Subject: **Ranchos de Candelaria Subdivision Grading and Drainage Plan**
(G13/D23)

Re: Rancho de Candelaria Subdivision Grading and Drainage Plan
Engineer's Stamp dated 12-15-03 (G13/D23)

NEW MEXICO QUALITY CONSULTANTS
RANCHOS DE CANDELARIA
GRADING & DRAINAGE PLAN

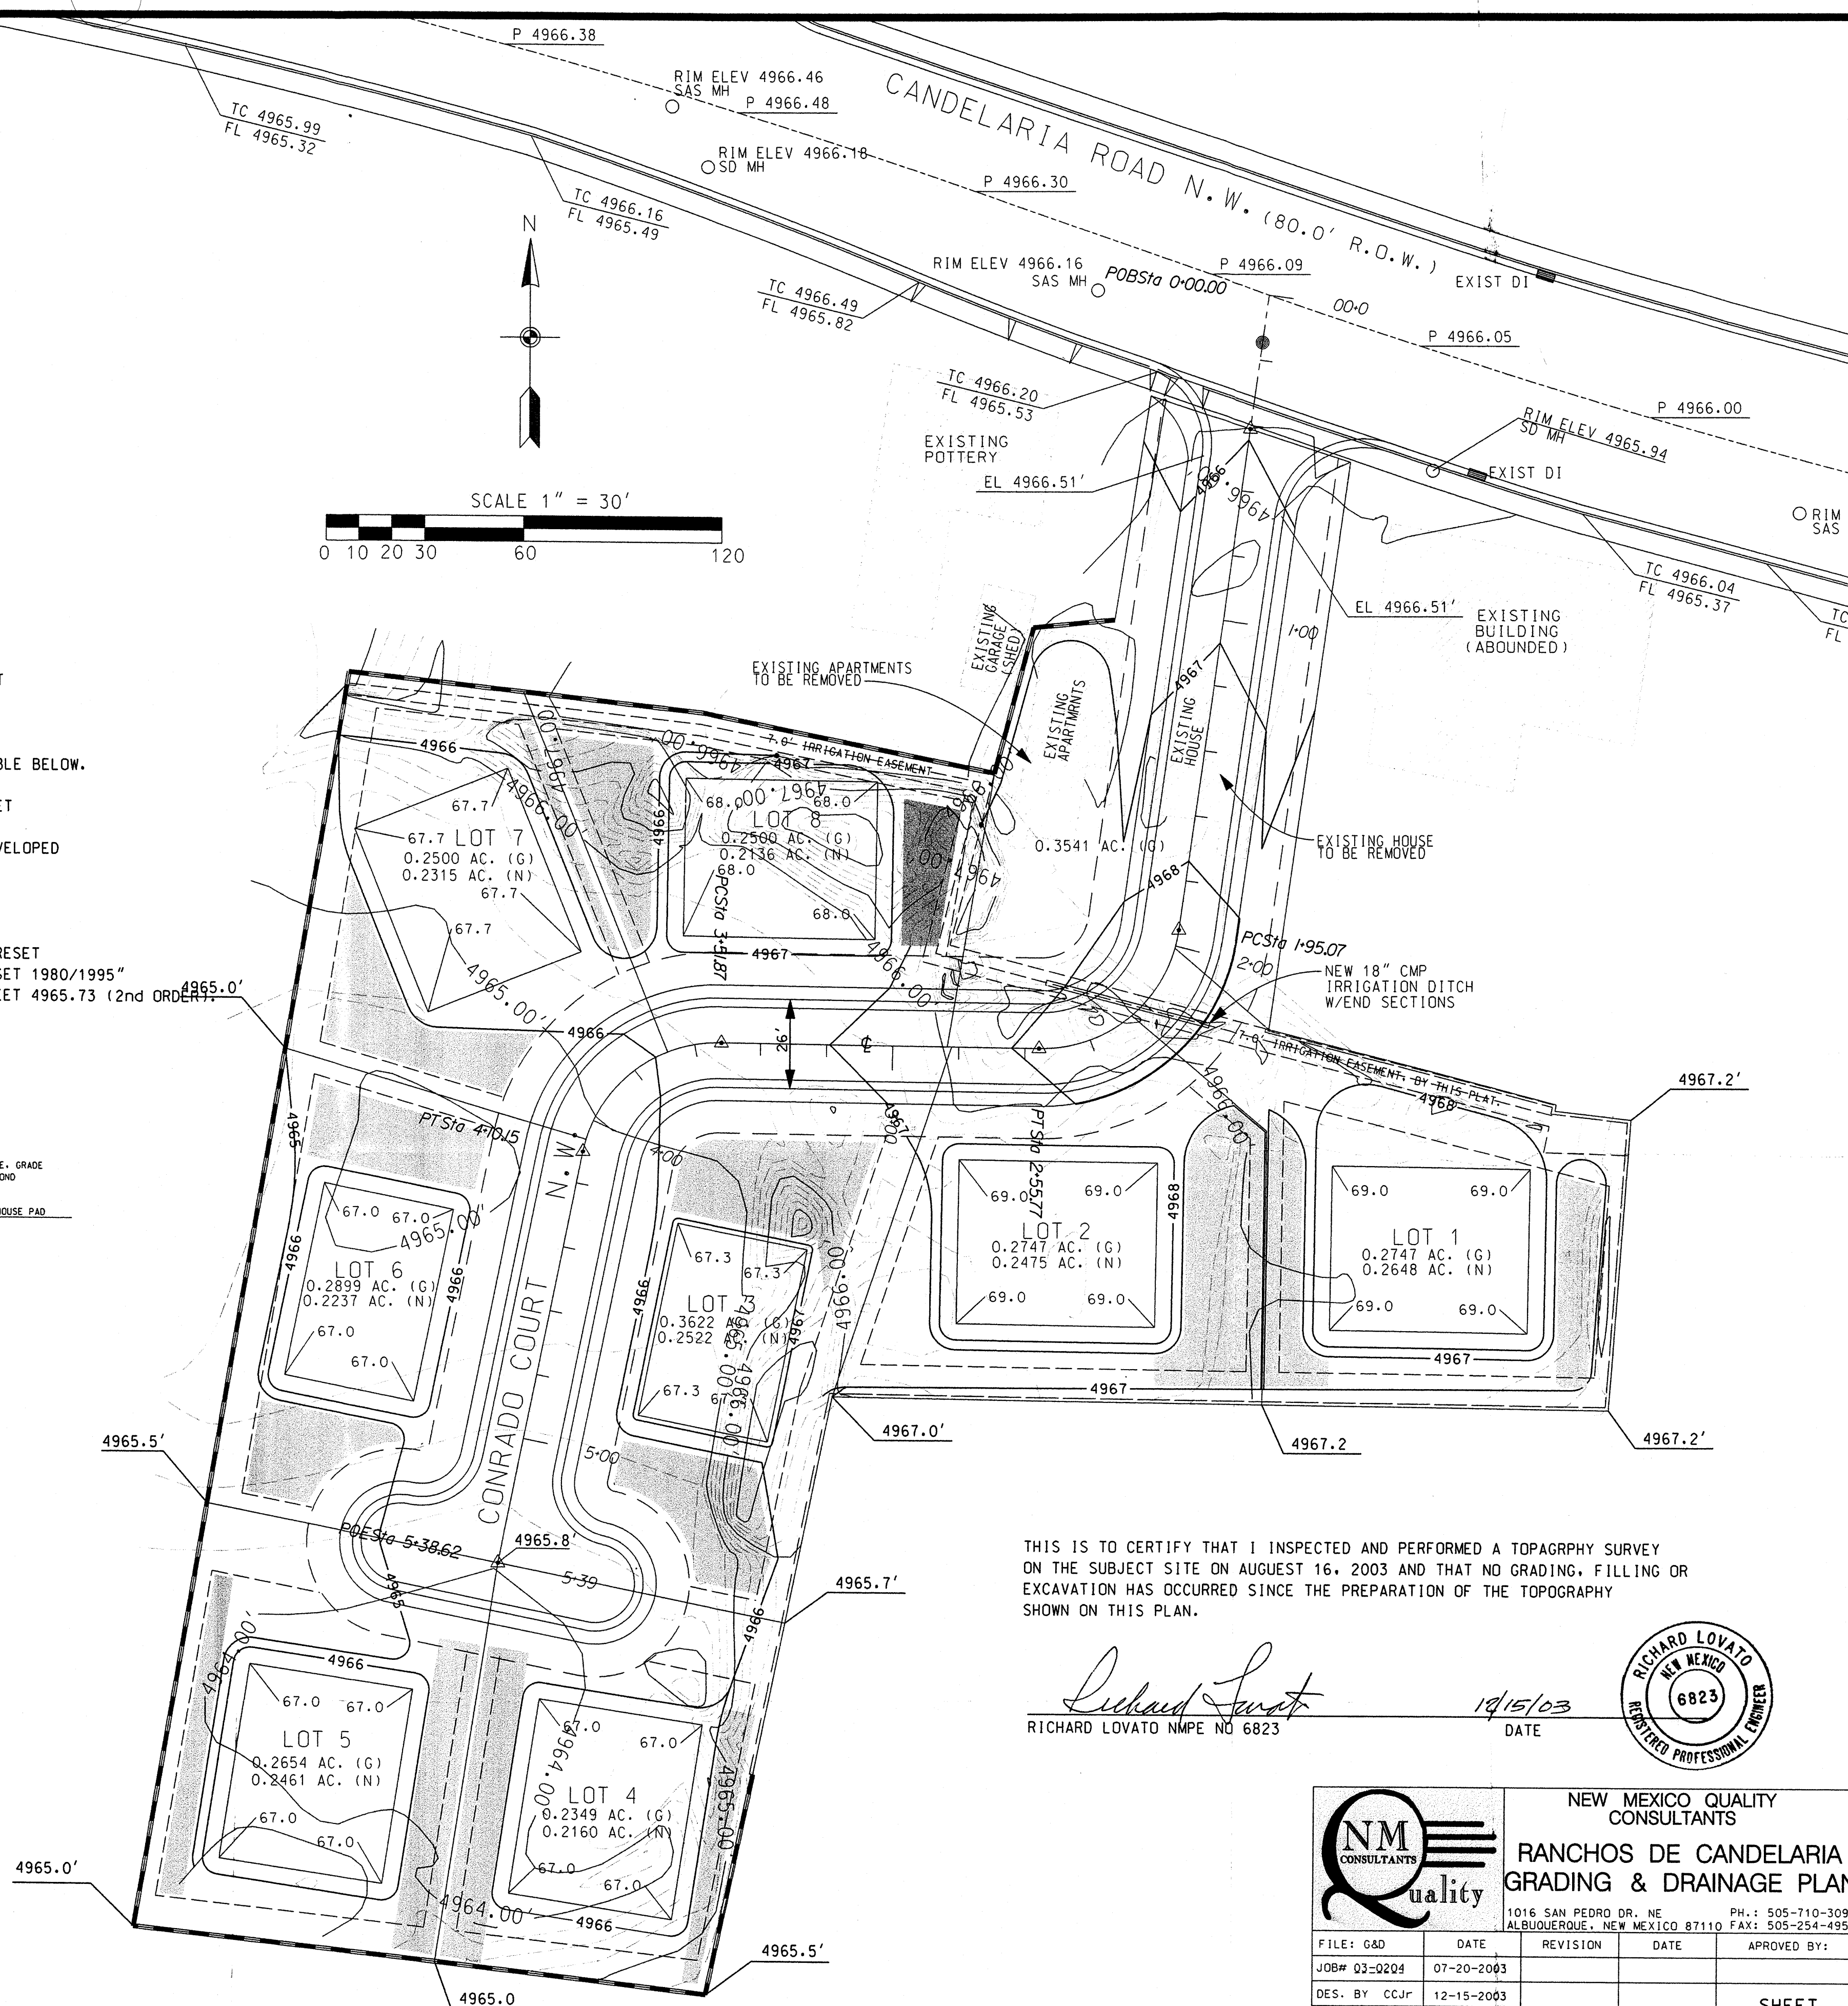
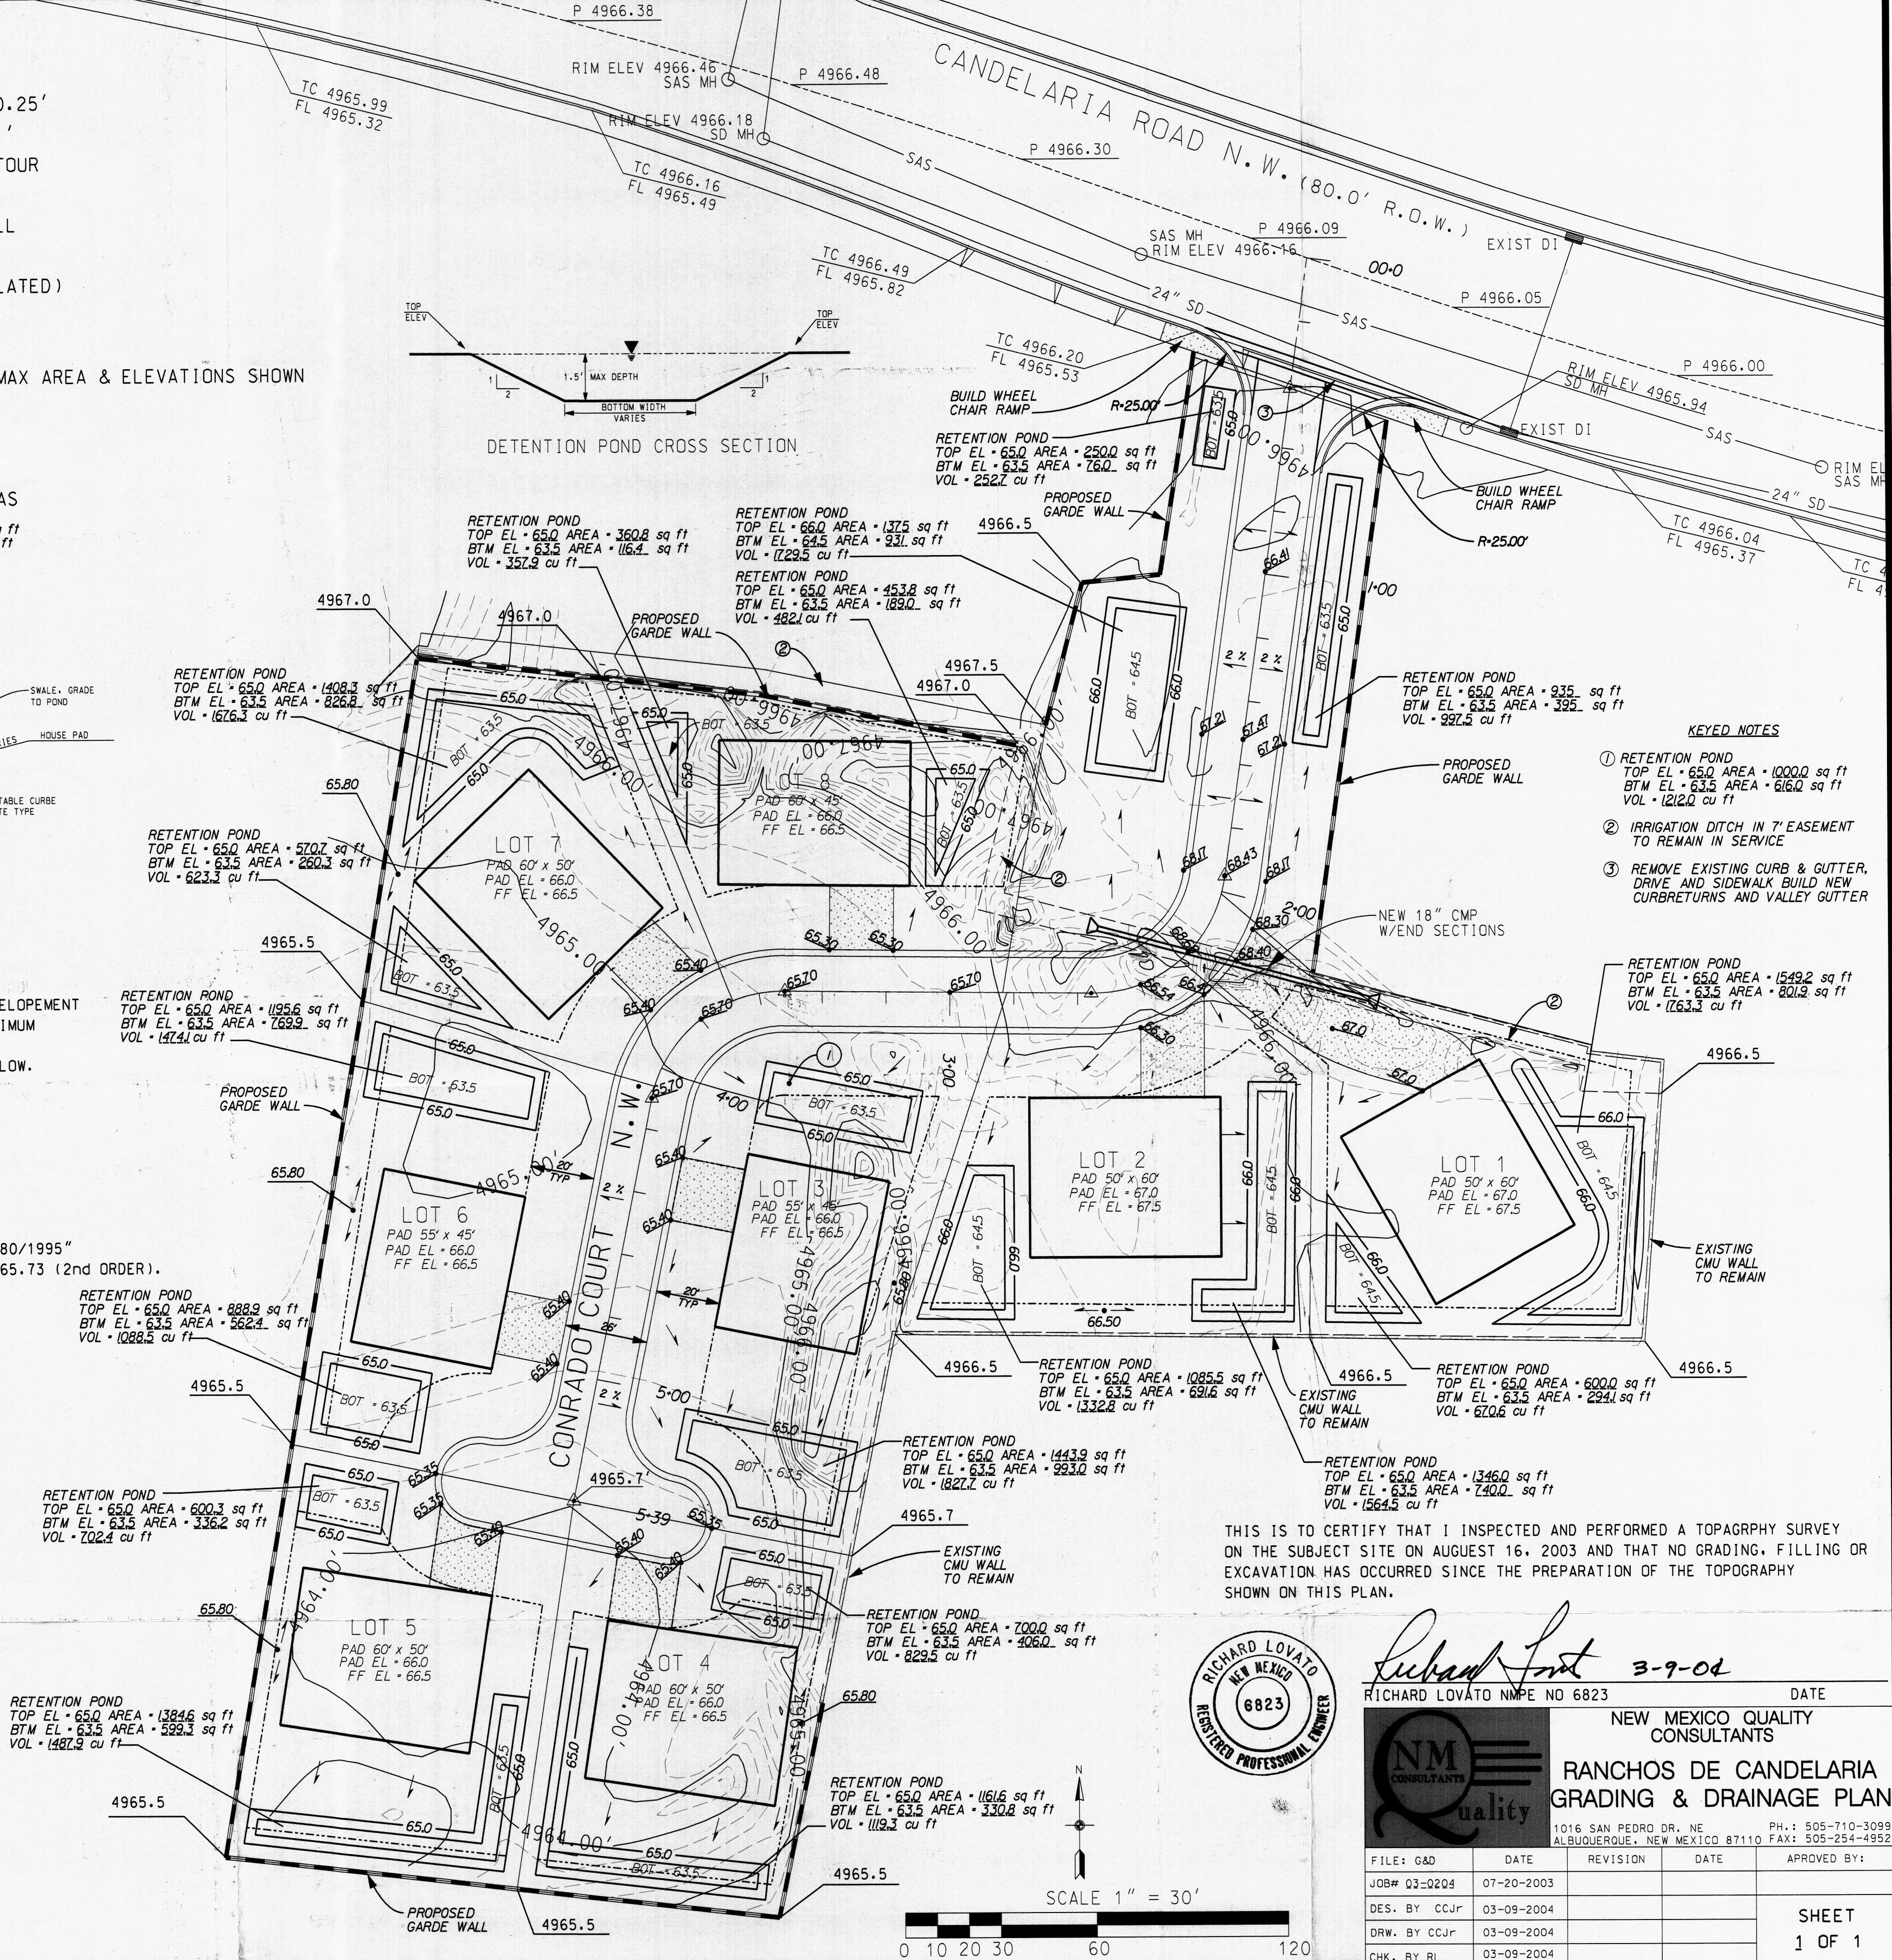
- How does lot 1 take access off the street when there is an 18" irrigation culvert ending at the curb?
- I am enclosing a copy of the flat grading scheme from the DPM. Item 7 states that there be no accessible storm drains in the area. Since there is one in Candelaria, you must either drain all lots into Conrado Court (which must drain to Candelaria) or create a sag in the street and install a storm drain.

This plan has been revised in accordance with our meeting with you on February 18, 2004. We addressed all the criteria for the "flat grading scheme" design and provided ponding for 100 year, 10-day storm as required.
